CITY OF ALBUQUERQUE

April 12, 2022

Re: Champion Xpress
2100 Central Ave. SW
Traffic Circulation Layout
Architect's Stamp XX-XX-XX (J13-D216)

Based upon the information provided in your submittal received 4-1-22, the above referenced plan cannot be approved for Building Permit until the following comments are addressed:

OVERALL SITE PLAN

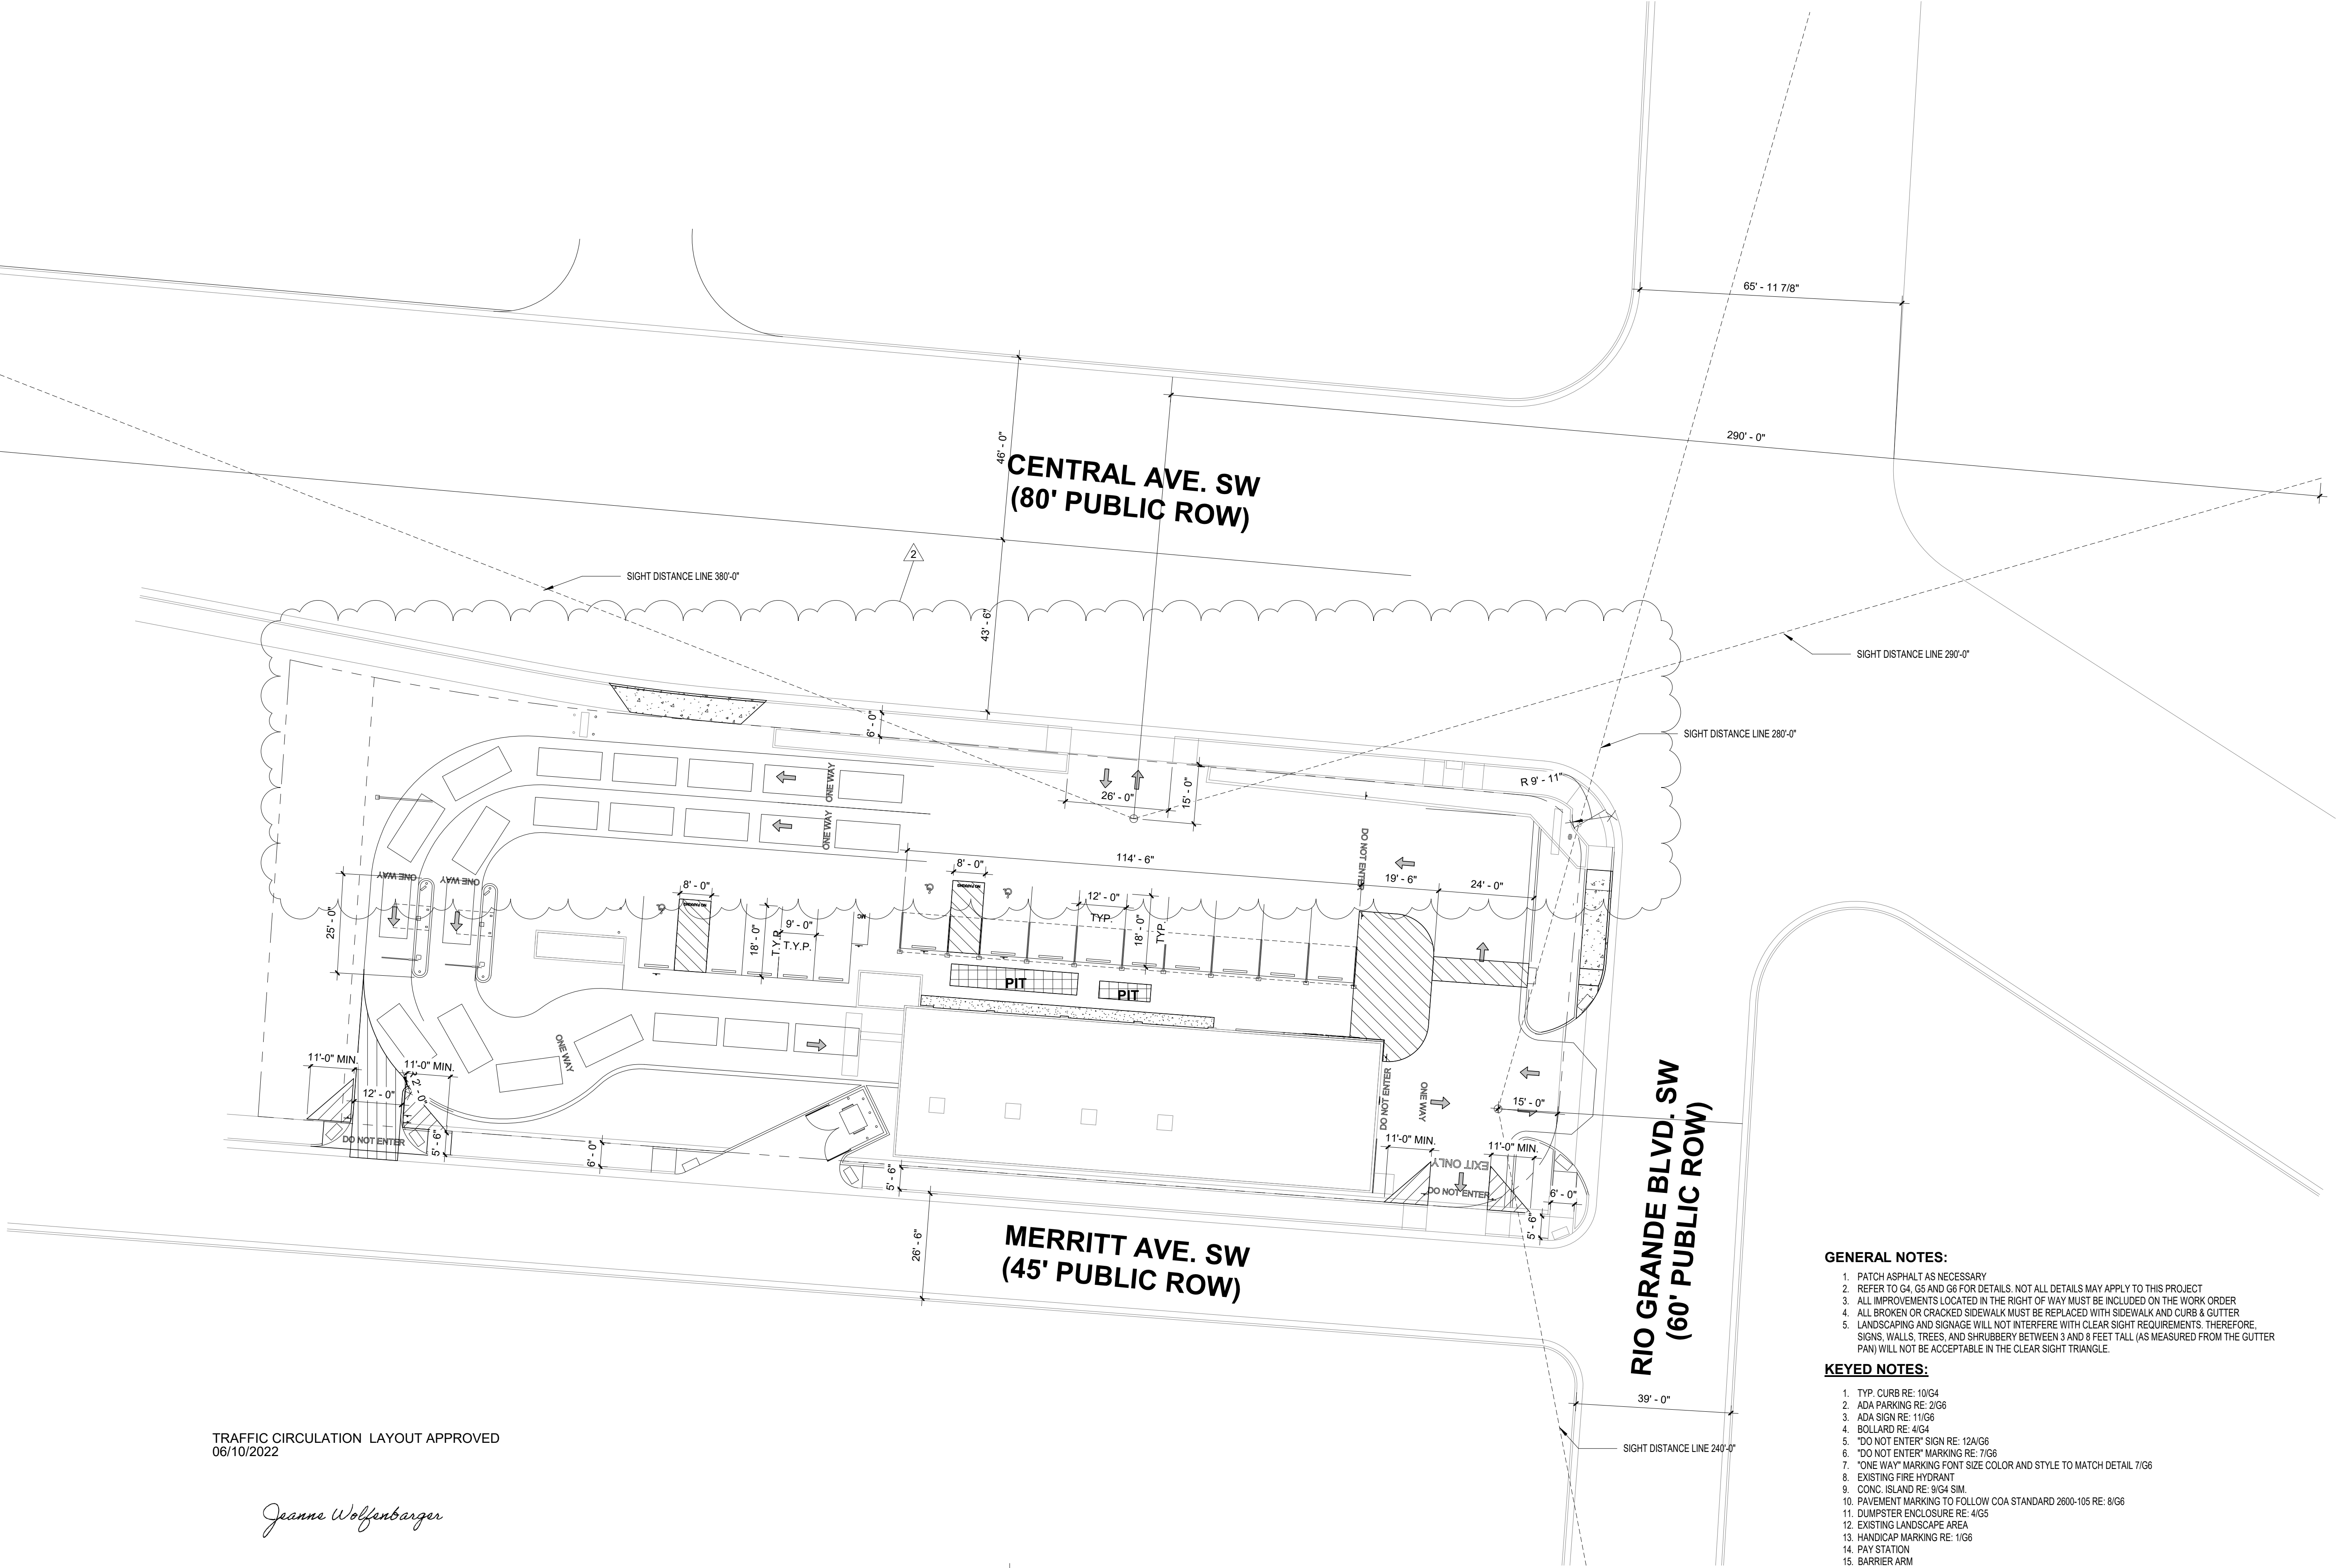
1. The traffic circulation layout must be stamped, signed, and dated by an engineer or architect licensed in the state of New Mexico.
2. Property line showed on site plan is incorrect. Per the GIS, property line must be placed at the back of the sidewalk.

10. Provide a copy of Fire Marshal Approval.
11. Show the Intersection Sight Distance for Central Ave. and Rio Grande Blvd. and add the following note to the plan: "Landscaping and signage will not interfere with clear sight requirements. Therefore, signs, walls, trees, and shrubbery between 3 and 8 feet tall (as measured from the gutter pan) will not be acceptable in the clear sight triangle.

12. Show the clear sight triangle for Merritt Ave. and add the following note to the plan: "Landscaping and signage will not interfere with clear sight requirements. Therefore, signs, walls, trees, and shrubbery between 3 and 8 feet tall (as measured from the gutter pan) will not be acceptable in the clear sight triangle.
